Application no: H17-1059-10

Description: Proposed replacement dwelling (retrospective)

Location: 4 Surfleet Reservoir
Surfleet
Spalding
Lincs
PE11 4DH
PE11 4DH

Amendment: Plan to show unauthorised window (dwg. no. B474-100D)

SIDE (NORTH EAST) ELEVATION 1:100

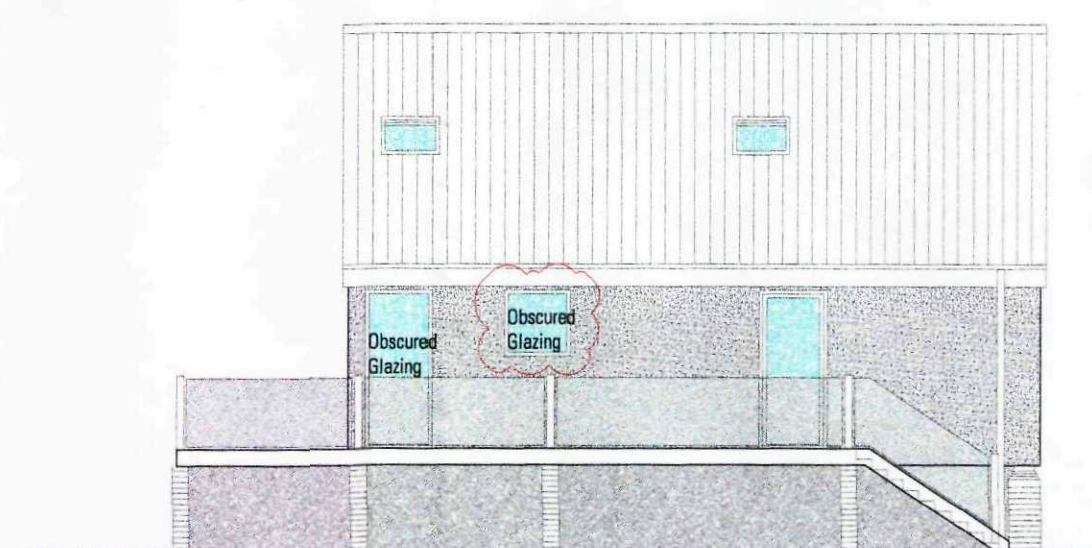
I've just been passed this file- I think I'm right in saying that the reason you've made this application is that an additional window has been inserted on the north east elevation facing towards the neighbouring dwelling? However, the drawing you've submitted appears to be the same as the one previously approved (same date/Dwg. No.) and doesn't show this additional window.

Can you confirm why you are making this application and provide an amended drawing as necessary.

We confirm that this application has been submitted to address the unauthorised window as shown on attached drawing.
